Application no: H16/1203/98

Description: Refurbishment works:
alterations and extensions

Location: White Hart Hotel
Market Place
Spalding
Lincs

TOWN AND COUNTRY PLANNING ACT 1990
NOTICE OF ACCEPTANCE OF AMENDMENT

6708/G/506 SCALE 1:50

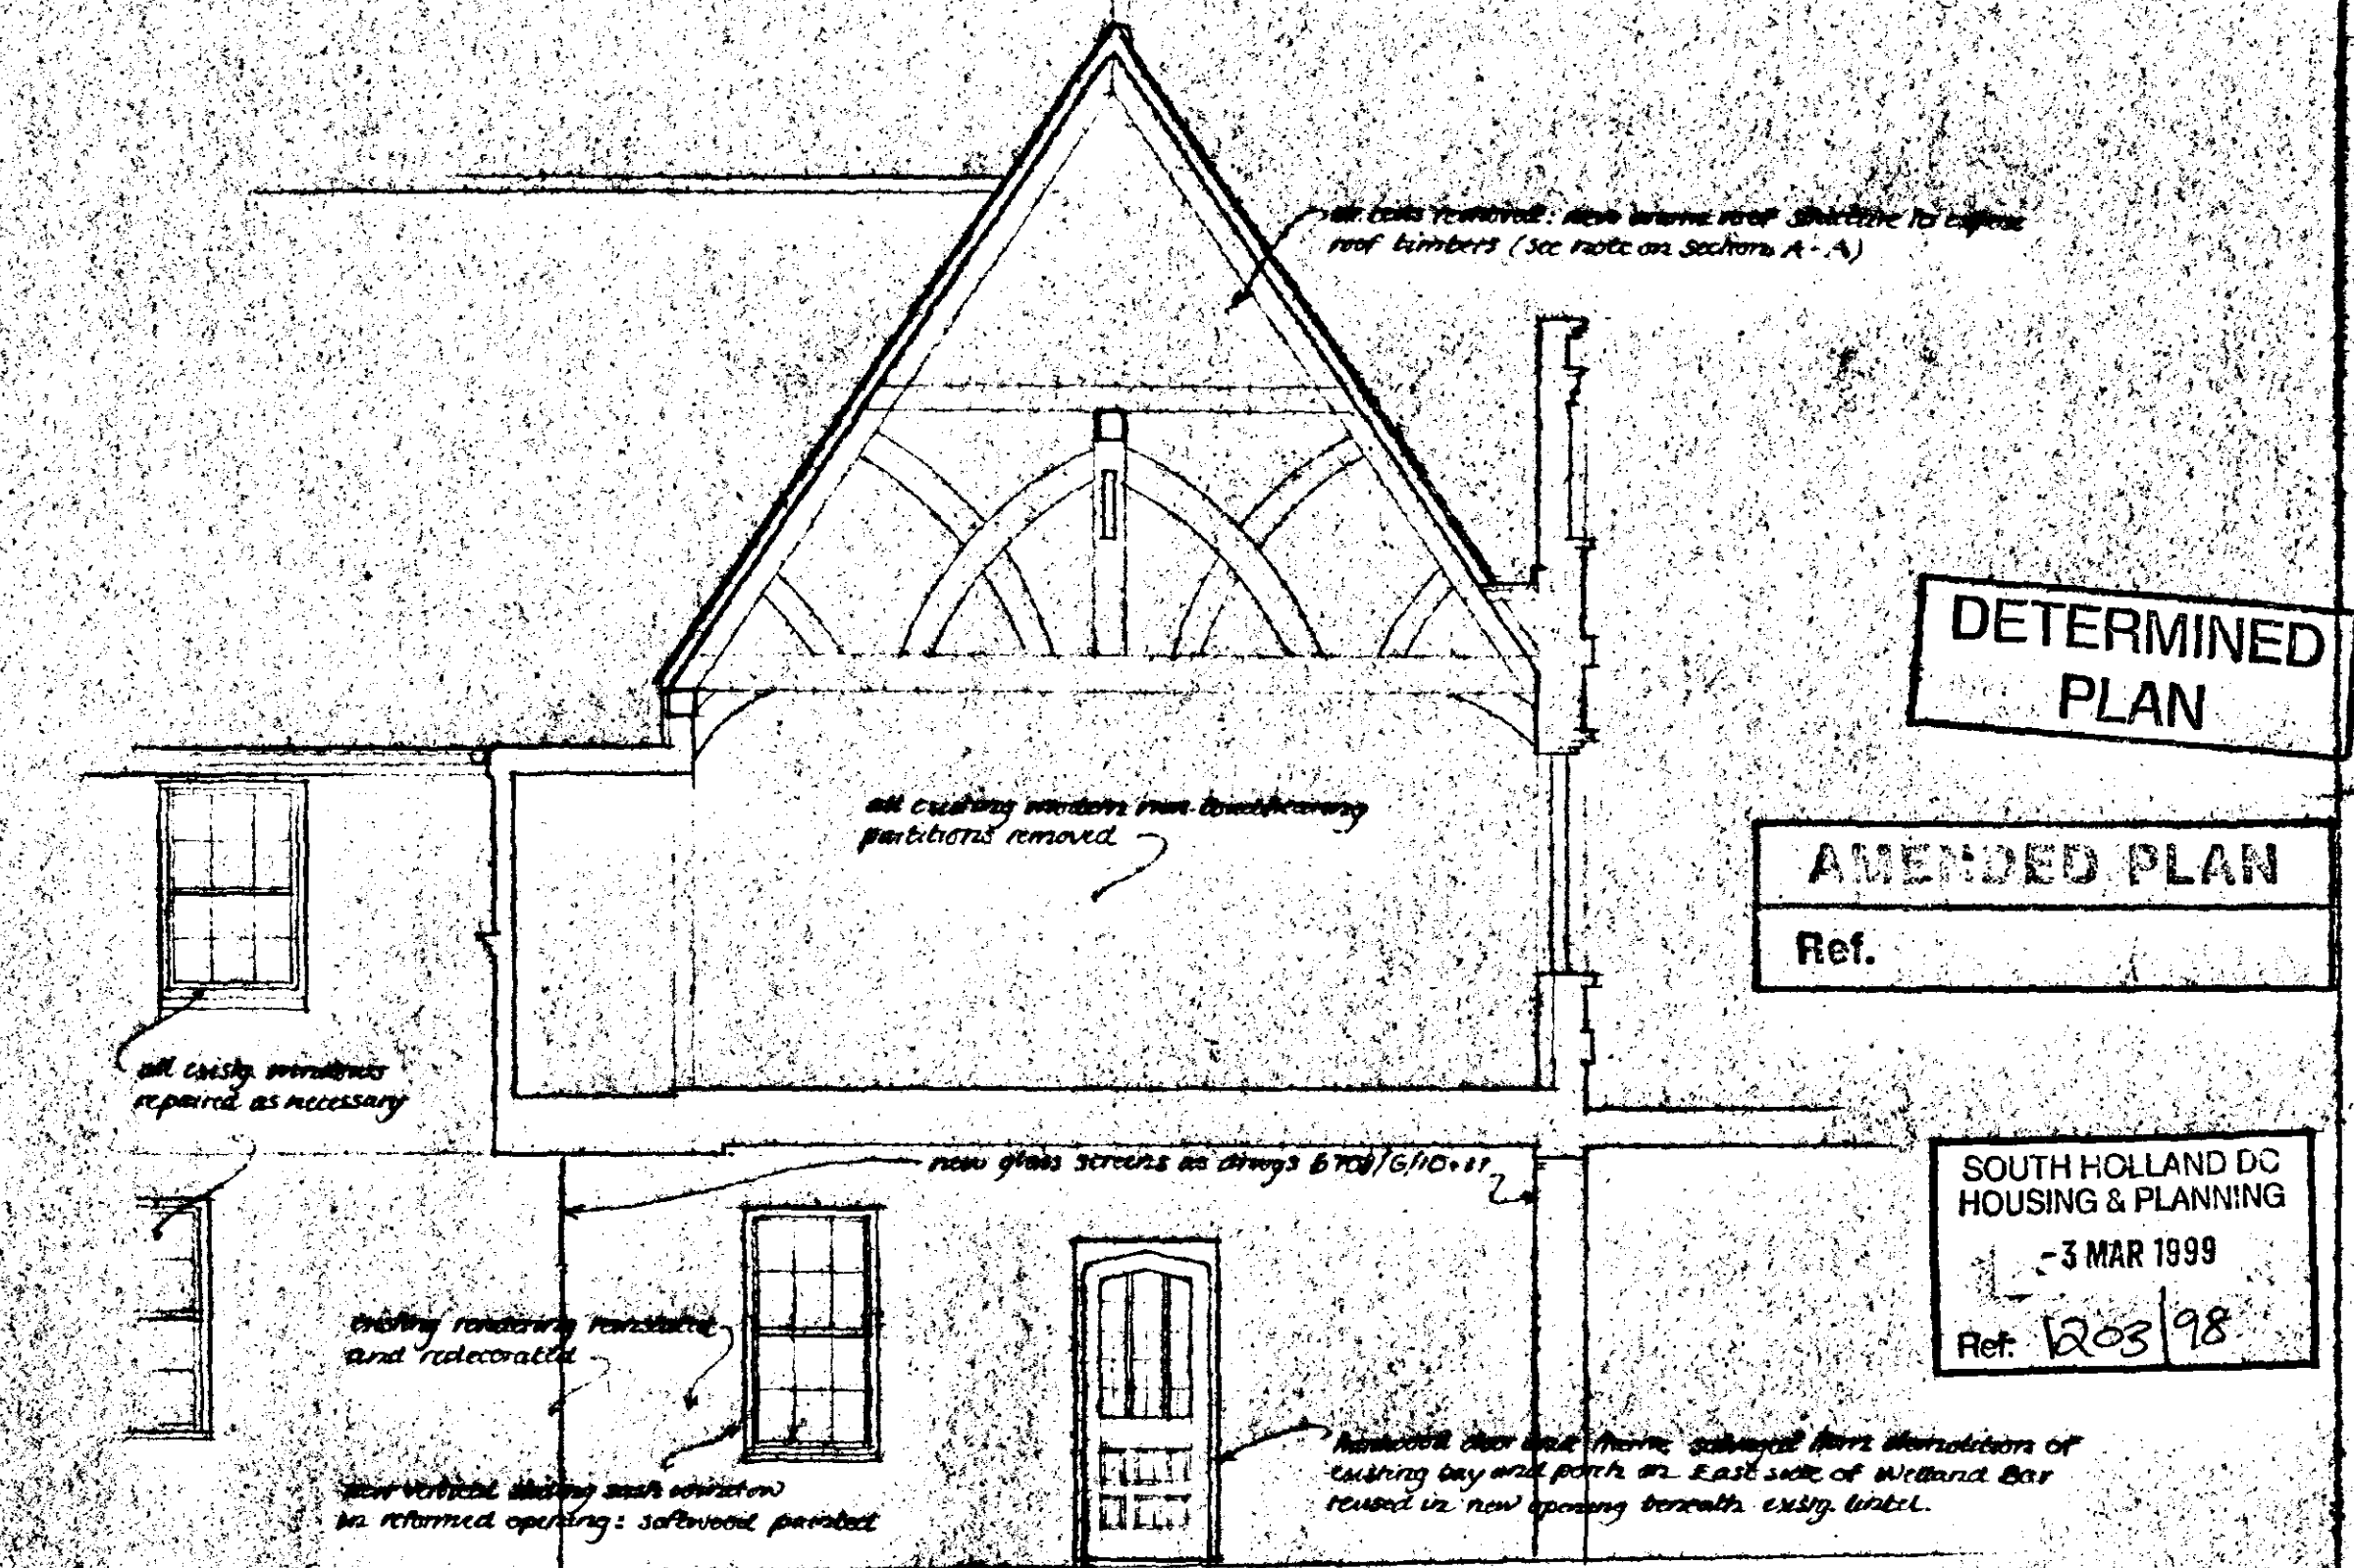
ALTERATIONS TO STAIRCASE INC. REUSE OF BALUSTRADES + BANNISTER ROIDS FOR ELSEWHERE IN THE PROPERTY.
ALTERATIONS TO DOORWAY TO ALLOW THE REUSE OF DOOR + FRAME FROM ELSEWHERE IN THE PROPERTY + TO PROVIDE FIRE ESCAPE FROM THE FIRST FLOOR.

Internal revision to staircase/Balustrades, re-use door & frame.
